CITY OF ALBUQUERQUE

March 21, 2023

Re: Petroglyph Plumbing
3031 Painted Rock NW
Traffic Circulation Layout
Engineer's Stamp 12-22-22 (G10-D029)

2 MOTORCYCLE PARKING DETAIL

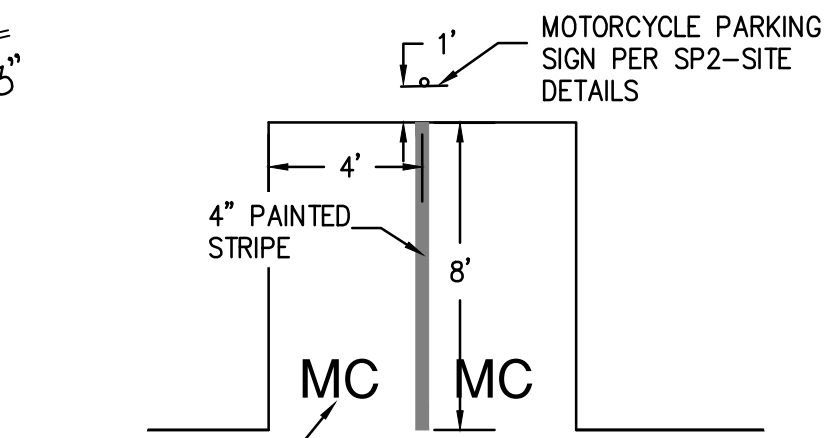
4. Motorcycle parking spaces shall be designated by its own conspicuously posted upright sign, either free-standing or wall mounted per the zoning code.

5. The pavement marking "MC" should be shown in the opposite direction for motorcycles entering the parking space.
6. All bicycle racks shall be designed according to the following guidelines:

3 BICYCLE PARKING DETAIL

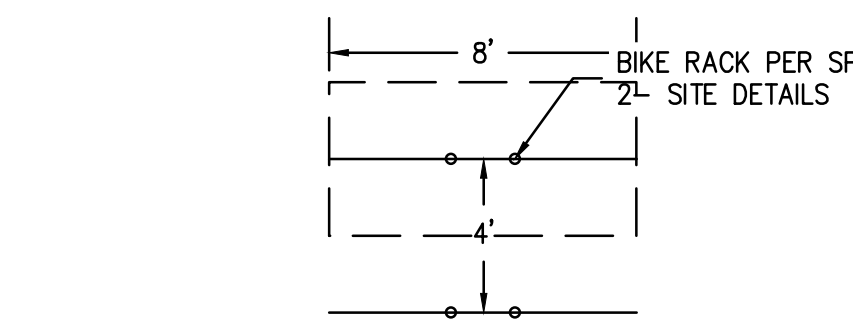
- a. The rack shall be a minimum 30 inches tall and 18 inches wide.
 - b. The bicycle frame shall be supported horizontally at two or more places. Comb/toaster racks are not allowed.

- c. The rack shall be designed to support the bicycle in an upright position. See the IDO for additional information.
 - d. The rack allows varying bicycle frame sizes and styles to be attached.

- e. The user is not required to lift the bicycle onto the bicycle rack.
 - f. Each bicycle parking space is accessible without moving another bicycle.

7. Bicycle racks shall be sturdy and anchored to a concrete pad.
8. A 1-foot clear zone around the bicycle parking stall shall be provided.
9. Bicycle parking spaces shall be at least 6 feet long and 2 feet wide.

TCL

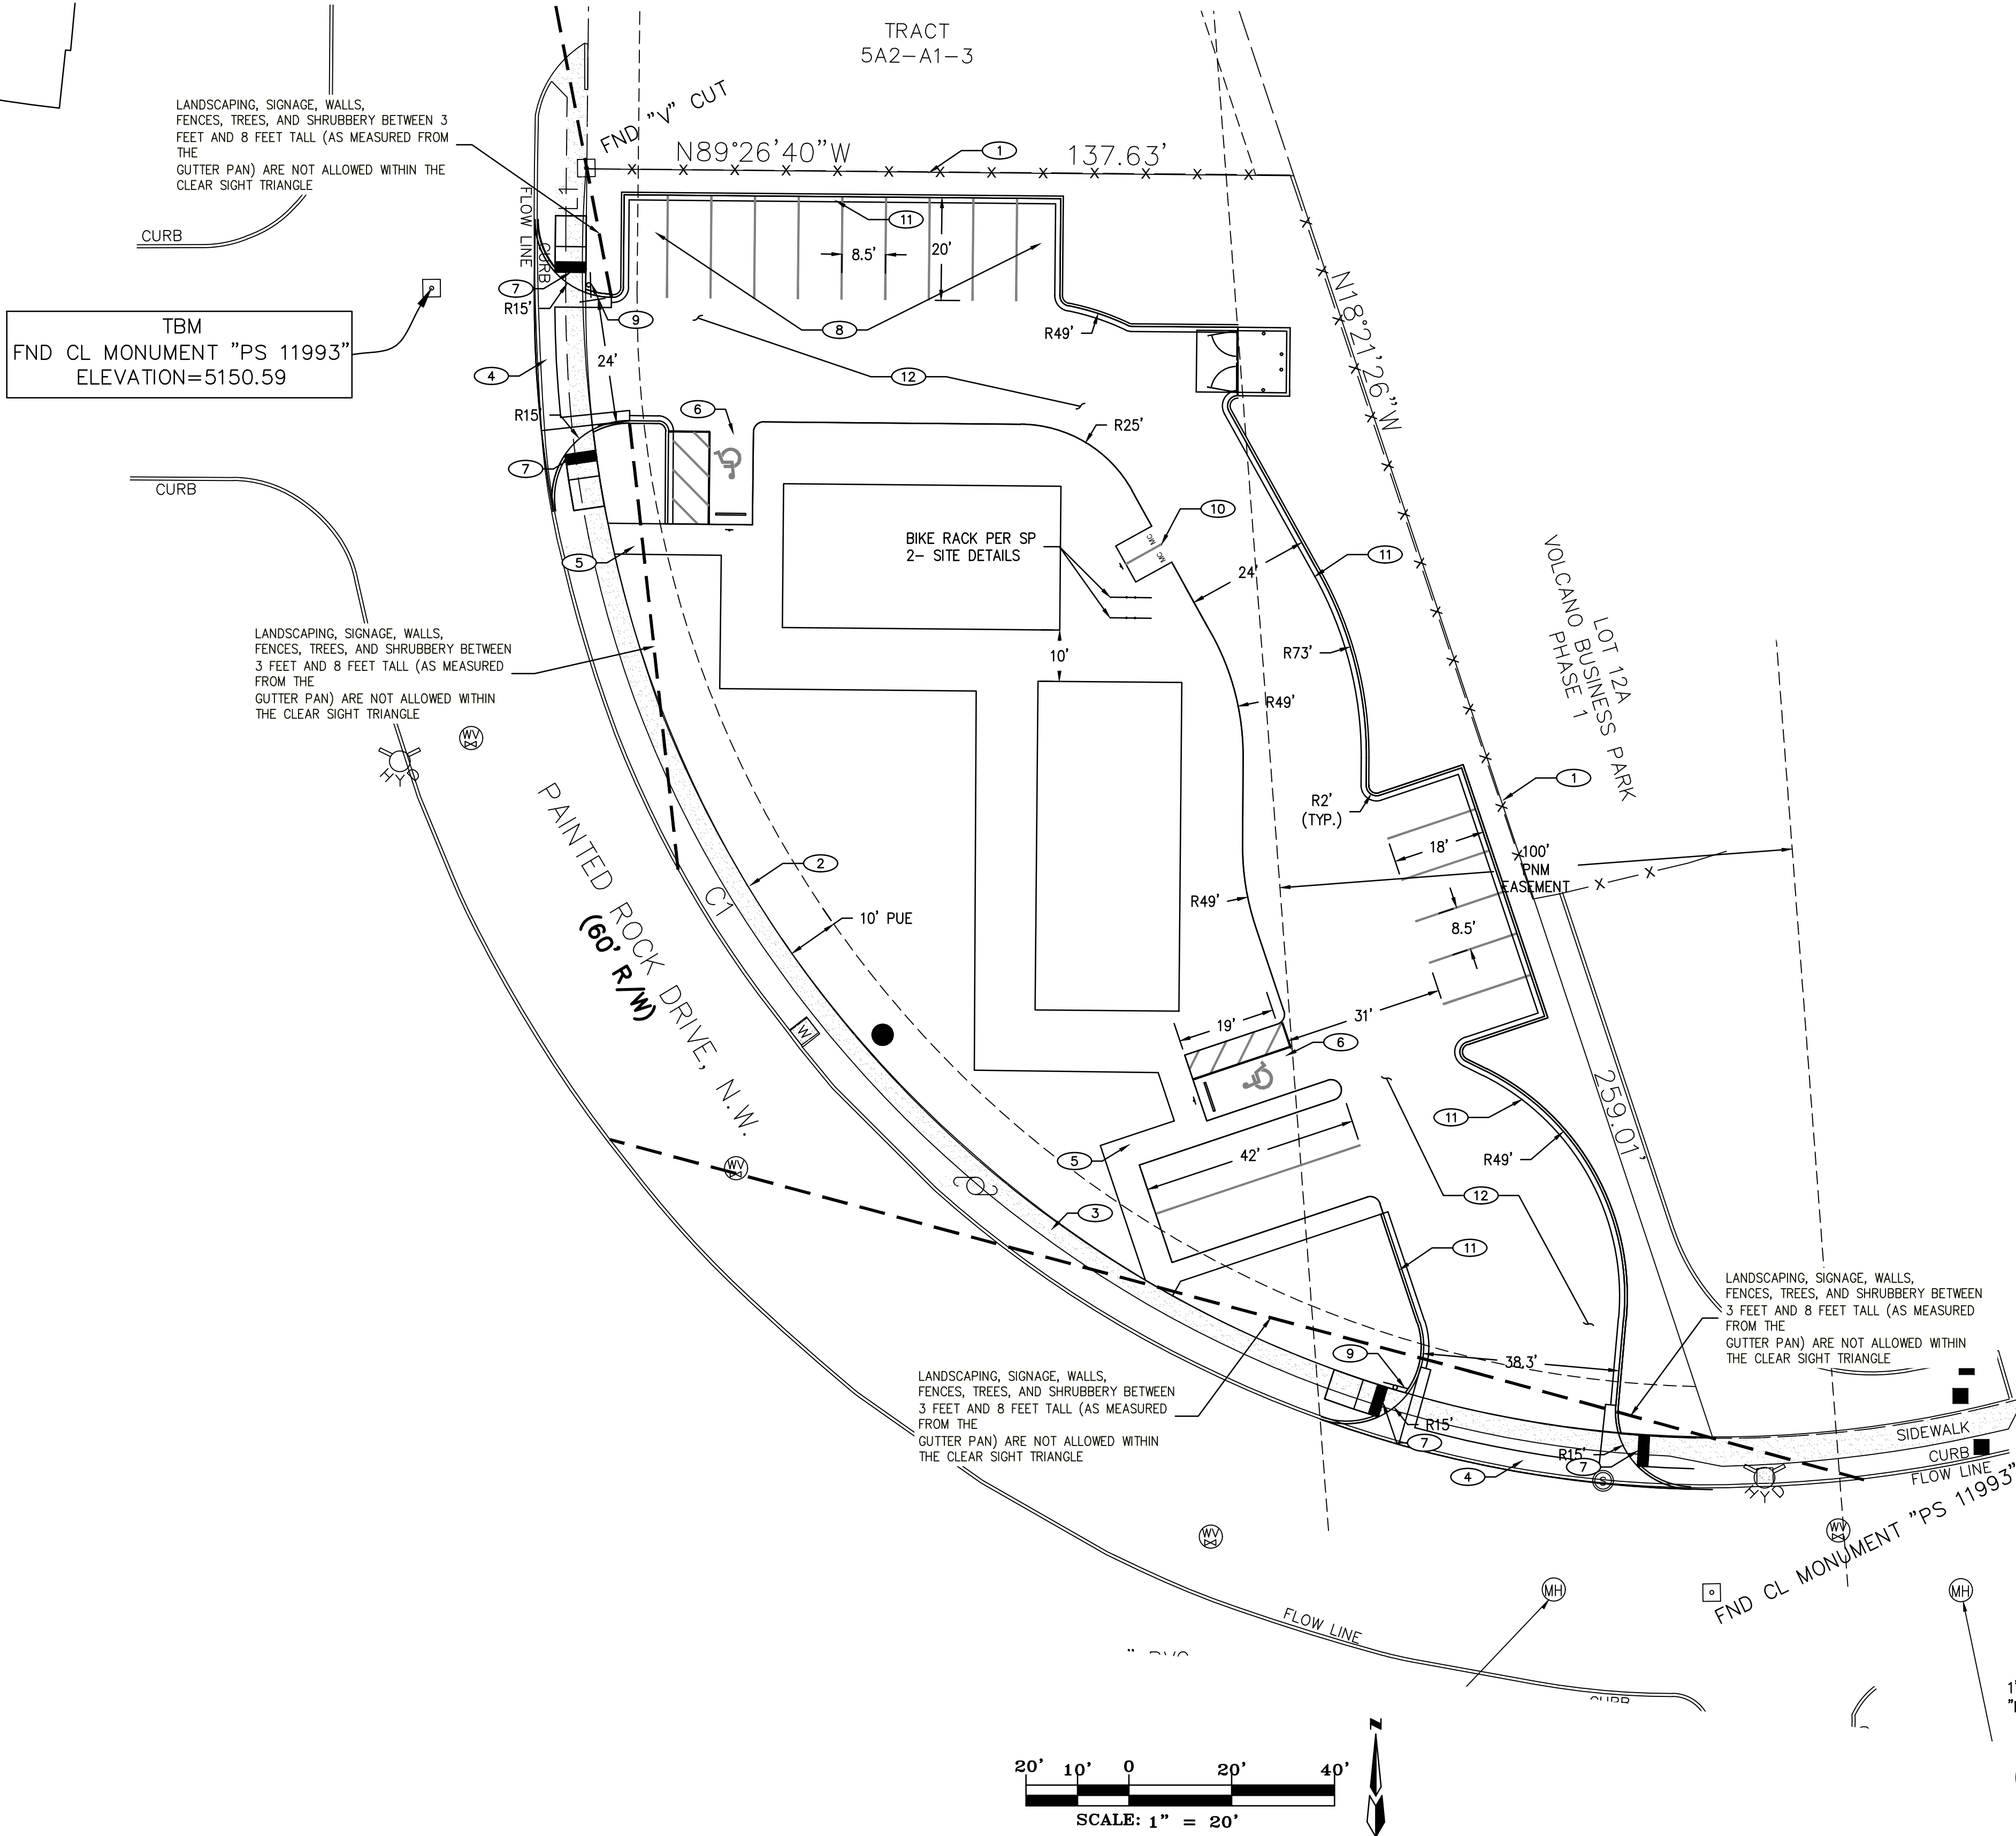
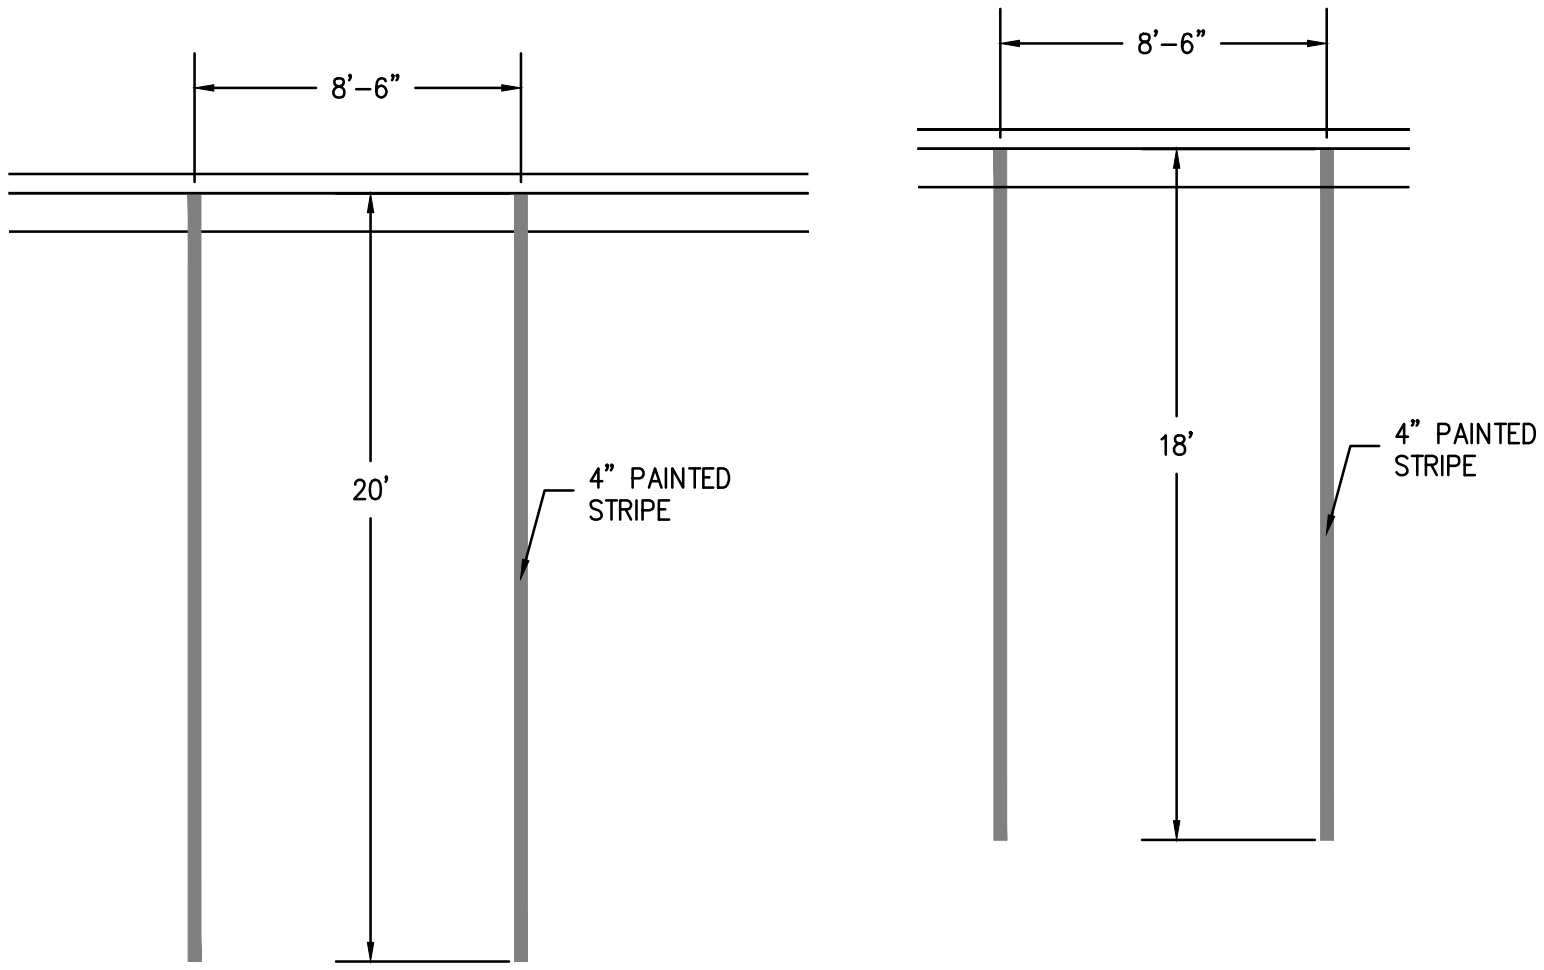
1. List the number of Motorcycle and Bicycle parking spaces required by.
2. Please define the property line.
3. Identify all existing access easements and rights of way width dimensions.

10. Per the IDO, a 6 ft. wide ADA accessible pedestrian pathway is required from the public sidewalk to the building entrances. Please clearly show this pathway and provide details.

11. Per DPM, a 6 ft. wide ADA accessible pedestrian pathway is required from the ADA parking stall access aisles to the building entrances. Please clearly show this pathway and provide details.

12. ADA accessible pedestrian pathway should not be placed behind parking space or adjacent to a vehicular way. Vehicle and pedestrian/wheel chair conflicts should be avoided as much as possible.

13. Curbing should be installed to delineate landscape, parking, and pedestrian ways and identify points of access. Please call out detail and location of barrier curb.

15. Please provide a copy of Fire Marshal approval.
16. It is not apparent what type of pavement surface is being proposed. A hard driving surface will be required as part of this proposed project for parking area and drive aisles.

17. Show the clear sight triangle and add the following note to the plan: "Landscaping and signage will not interfere with clear sight requirements. Therefore, signs, walls, trees, and shrubbery between 3 and 8 feet tall (as measured from the gutter pan) will not be acceptable in the clear sight triangle.

18. Please specify the City Standard Drawing Number when applicable.
19. Add a note stating "All broken or cracked sidewalk must be replaced with sidewalk and curb & gutter." A build note must be provided referring to the appropriate City Standard drawing.
